Parks and Wildlife

August 11, 2023

Re: Monument Glamping Special Use

Colorado Parks and Wildlife (CPW) has reviewed the information about the Monument Glamping II plan located at 18045 Highway 83 Colorado Springs, CO 80908 in El Paso County Colorado. CPW staff has seen the site and offers the following comments for your consideration.

SITE PLAN

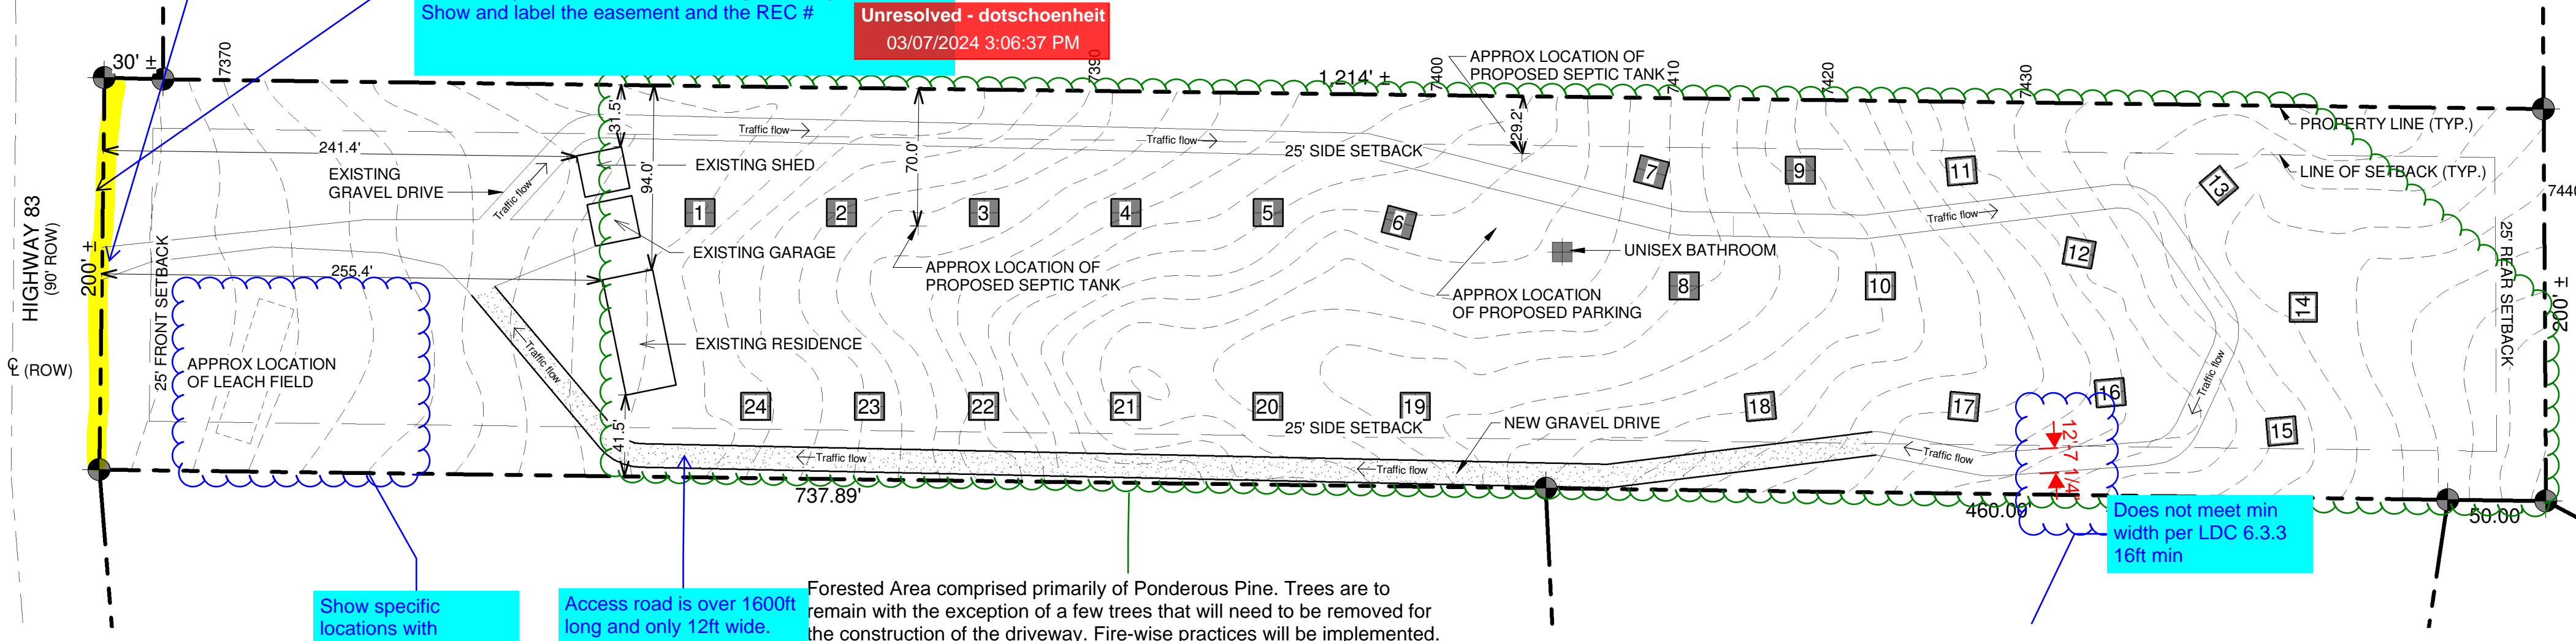
CPW is concerned that some trees could be removed during the development process. The concern lies in the fact that trees may be currently occupied or be historic bird nesting sites. Please take care to avoid removal of trees with visible nests within the canopy. We recommend leaving as many native healthy trees on site and replacing trees that are removed with comparable native species on a 3:1 basis. Dead trees, or snags, provide valuable perching areas for native birds or nesting opportunities for cavity nesting species. Snags should be left standing where possible.
